# PORTLAND MAINE

February 18, 2016

Project Name: 3 Story, 2- Family Home  
Project ID: BP 2015-02404  
Address: 40 Quebec Street  
CBL: 014 H 003 001  
Applicant: Matthew Murrell and Katherine Howe  
Planner: Philip DiPierro

On February 18, 2016, the Planning Authority approved with conditions a Level I: Minor Residential application for a 3 story, 2 family home at 40 Quebec Street. This approval is based on the review of the site plan submitted by Gologic plan sheet A1.1 with a current issue date of 2/10/16. The site plan consists of a 3 story 2-family structure with carport for two vehicles and a garage that has parking for one vehicle. To address stormwater on site, the applicant has proposed to construct a stormwater infiltration trench on the west side of the structure that receives roof drainage from a scupper and downspout system. The infiltration trench drains into a rain garden that wraps around the south and east sides of the structure. The rain garden infiltrates stormwater into the soils, and will include an overflow device (as a condition of approval) that drains excess stormwater into a crushed rock filter that drains through the retaining wall along the site's str

1 Site Plan
3/16" = 1'-0"

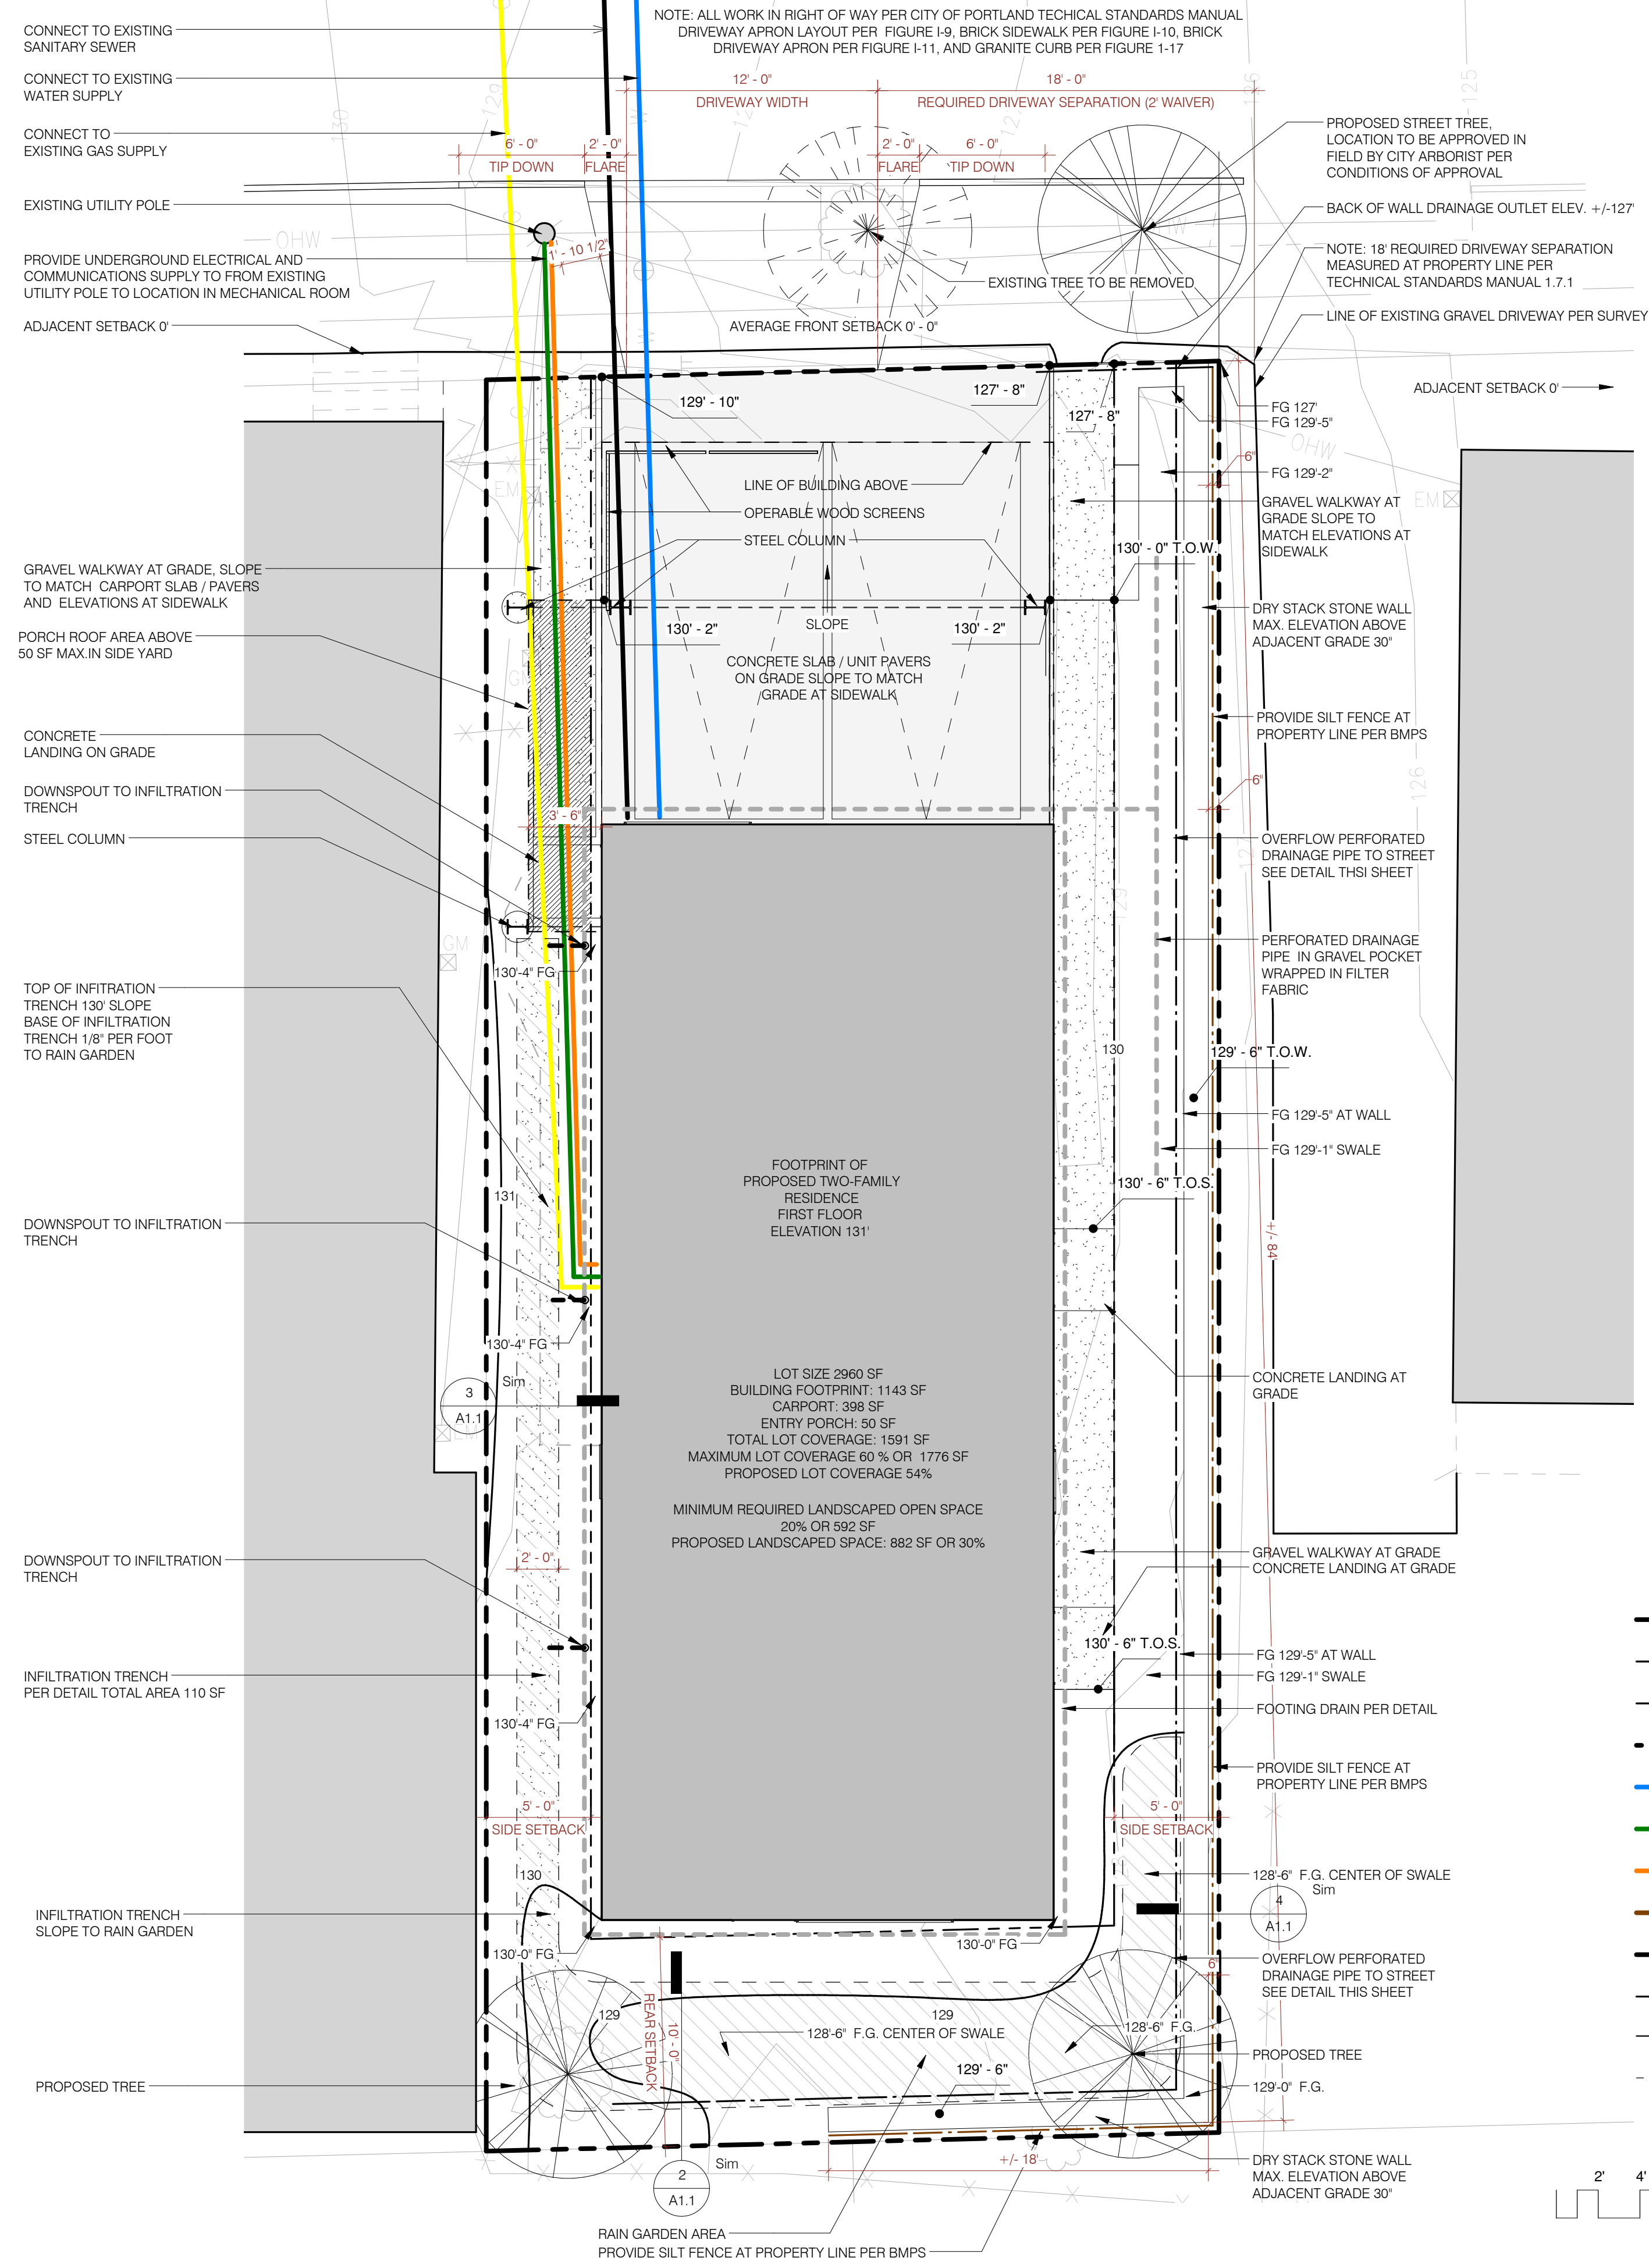
Section 1.7.1. of the City of Portland's Technical Manual requires ".....a minimum distance of twenty (20) ft. spacing between adjacent driveways." The applicant is requesting a waiver of this standard and proposing a driveway separation of nine feet. The standard for granting a waiver of this requirement appears at Section 526(f) of Chapter 14 of the City Code. Under that section, a waiver may be granted upon a showing of extraordinary or undue hardship and that the grant of the waiver would be in the public interest.

After thorough review and having consulted with both the Deputy City Engineer, and the City's consulting traffic engineer, the Planning Authority does not find that an undue hardship sufficient to justify such a substantial waiver from the usual requirement exists in this case. Unlike some properties in other areas of the City, the City's Code does not require that this property provide any off-street parking. Therefore, there is no hardship created by the 20-foot standard nor is there any reason from regulatory or land use perspective why the usual standard cannot be met – no driveway is required. Additionally, granting the waiver as requested would result in the loss of an existing on-street parking space, something that is contrary to the public interest. However, out of recognition of some hardship created by the existence of a utility pole on the western side of the proposed driveway, such that the proposed driveway cannot be shifted to fully accommodate the 20-foot separation requirement, and because an 18-foot separation would continue to preserve the existing on-street parking space, Public Works is supportive of a partial, more-modest 2-foot waiver of the usual standard. Therefore, a partial waiver is granted to allow an 18-foot (rather than a 20-foot) driveway separation. As a condition of the waiver approval, the applicant must submit a revised site plan that meets the driveway separation requirements outlined below by Assistant City Engineer, David Margolis-Pineo.

At the direction of the Public Works Department, "the applicant is to close the proposed driveway cut width to 12 feet, increasing the separation between driveways to 18 feet, and offer a waiver from the required 20 feet of separation between driveways to 18 feet, resulting in a waiver of 2 feet."

1. Prior to the issuance of the building permit the applicant shall revise the site plan so that it meets the partial waiver criteria outlined above for the curb cut and driveway spacing as follows; - the applicant is to close the proposed driveway cut width to 12 feet, increasing the separation distance between driveways to 18 feet,

2. Prior to planting the street trees, the applicant shall meet with the city arborist to field locate the proposed street trees,
3. Prior to the issuance of the building permit the applicant shall revise the site plan and include a detail of the stormwater overflow device that is to be constructed between the rain garden and the retaining wall. The detail is to be submitted, reviewed and approved by the Planning Authority.
